DECISION DELEGATED TO HEAD OF PLANNING

Application No: H02-0667-24 **Applicant:** Mr A Cooper

Proposal: Details of construction management plan, site levels, landscaping, boundary treatments, external doors & windows, rooflights & design & position of meter boxes (Conditions 2, 4, 5, 6, 8, 9, 10 and 13 of H02-0081-24)

Location: Barn Lodge Hereward Way Crowland

Notes for fencing, landscaping and planting

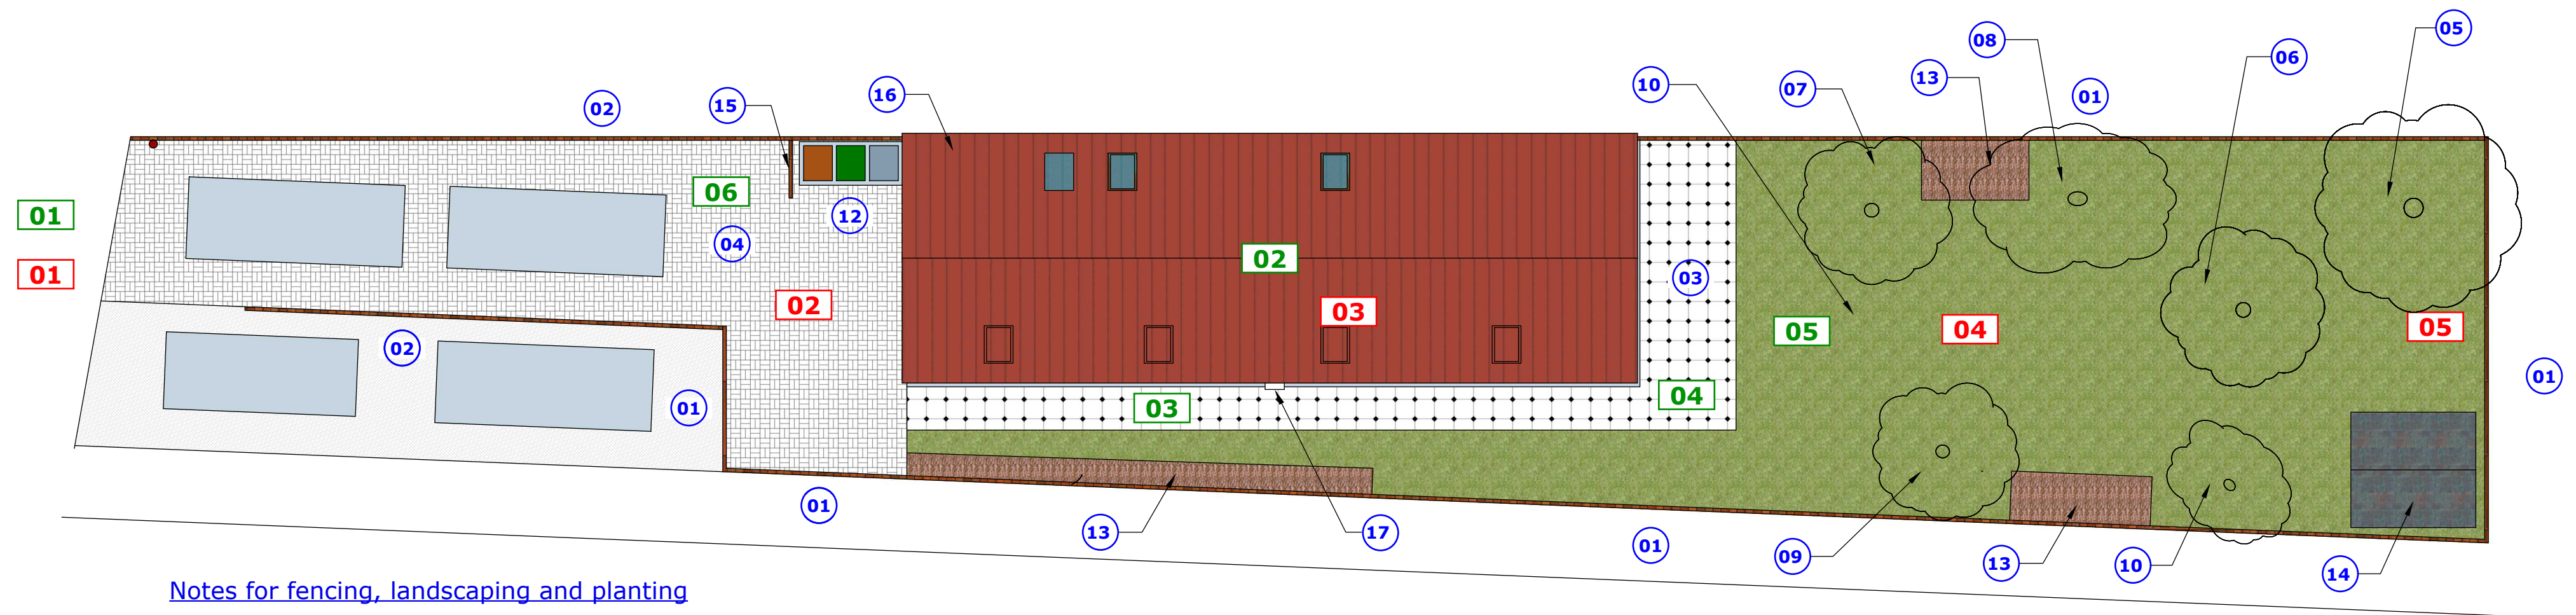
The applicant has provided a plan titled 'landscaping, fencing and site levels' this shows the levels across the site as well as the FFLs of buildings. These are considered acceptable (it should also be noted that the FFLs of the dwelling are complicit with the requirements of condition 3 which states they must be 500mm above existing ground levels).

The applicant has provided a plan titled 'landscaping, fencing and site levels' this shows the landscaping on site which is considered acceptable. Given the proposal is a single plot the post planting maintenance will fall upon the owner.

The applicant has provided a plan titled 'landscaping, fencing and site levels' this shows the proposed fencing across the site. The approach is considered acceptable in relation to its character and amenity effects.
